# Rezoning Transportation Analysis

Petition Number: 2023-001

General Location Identifier: 07112129, 07112130, and 07112131.

Date	Description
5-24-23	First Review (TM)

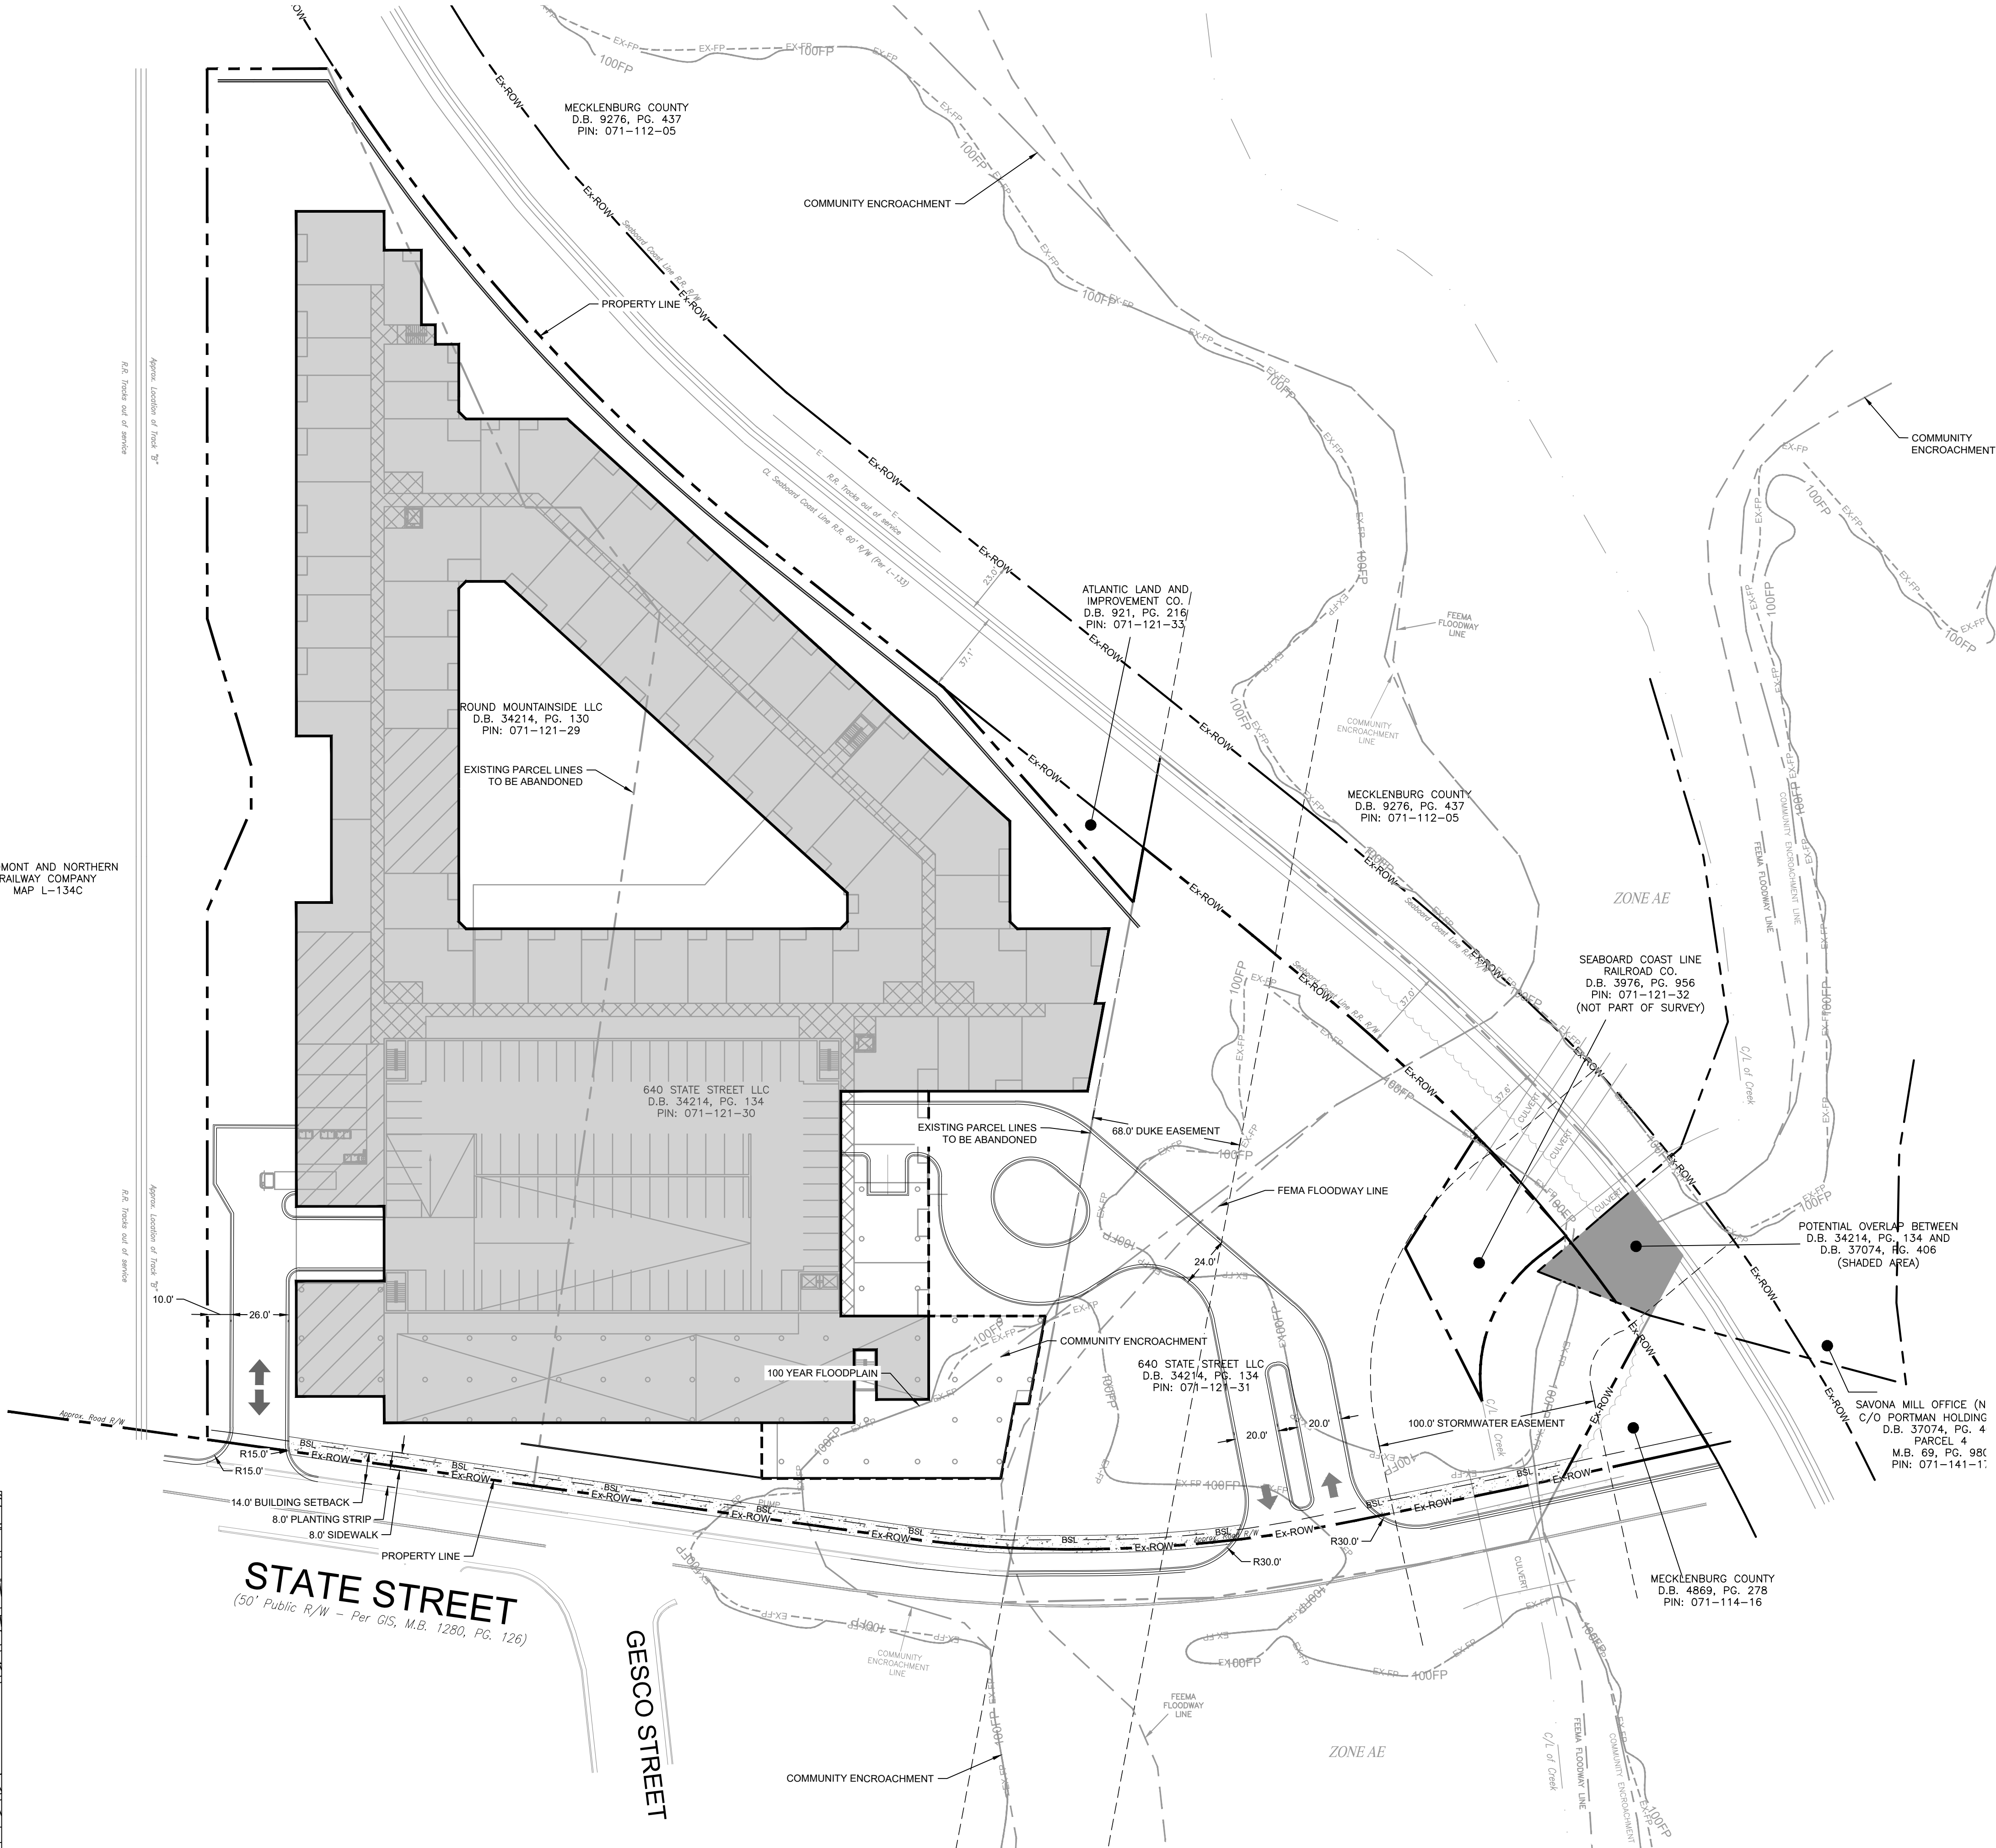
- a. **State Street:** The future location of curb and gutter is in its existing location.

NOTE: Additional distance from center line to back of curb may be required in locations where a median is present or around intersections and interchanges.

Label and dimension the curb and gutter from the centerline for each road on the site plan.

4. Revise site plan and conditional note(s) to commit to dedicate 35.5-feet of right-of-way from the road centerline. The site plan shall label and dimension the right-of-way from the road centerline.
5. Add a conditional note specifying "A Right-of-Way Encroachment Agreement is required for the installation of any non-standard item(s) (irrigation systems, decorative concrete pavement, brick pavers, etc.) within a proposed/existing City-maintained street right-of-way by a private individual, group, business, or homeowner's/business association. An encroachment agreement must be

2. Adequate sight triangles must be reserved at the existing/proposed street entrance(s). Two 35' x 35' sight triangles (and two 10' x 70' sight triangles on NCDOT-maintained streets) are required for the entrance(s) to meet requirements. All proposed trees, berms, walls, fences, and/or identification signs shall not interfere with sight distance at the entrance(s) and shall be identified on the site plan.
